Comments on the applicant's Response to the Examining Authority's First Written Questions (EN070008/EXAM/9.9) on behalf of the residents of Corner Farm

Interested Party reference number: 2004715

Deadline 3

Fig. 1 Alternative E-1B/E-2 Route (with link in pink)

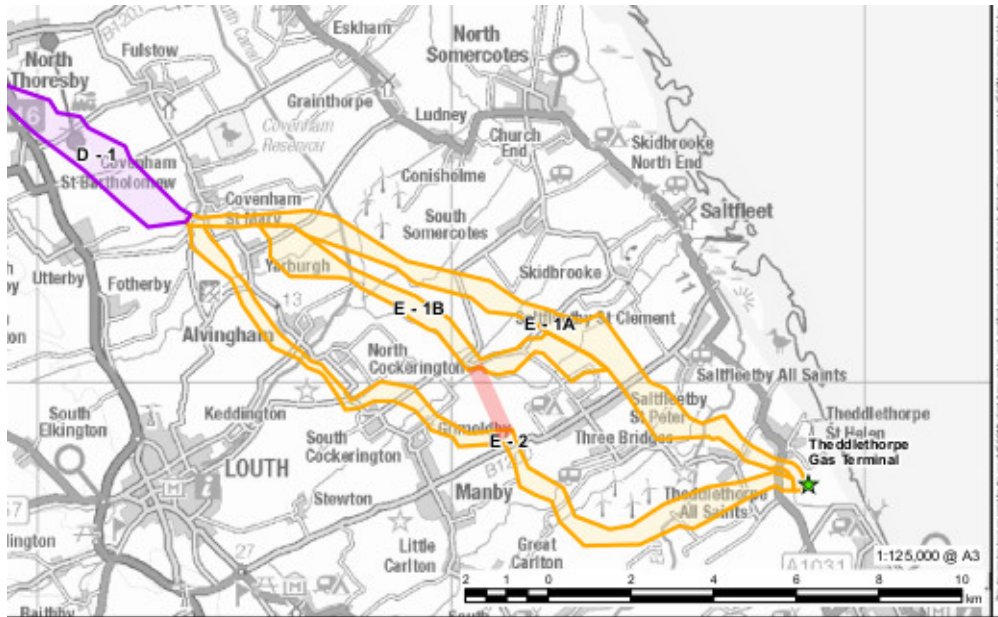
2.20.19 – The applicant fails to say why it would not consider reversing the "minor diversion to the east" on route E-2 in the interests of safety. It has shown only mitigation of risk and not of consequences. Safe distance is intended to mitigate consequences. The applicant's determination not to address the consequences of pipeline rupture shows a somewhat cavalier attitude to public safety.
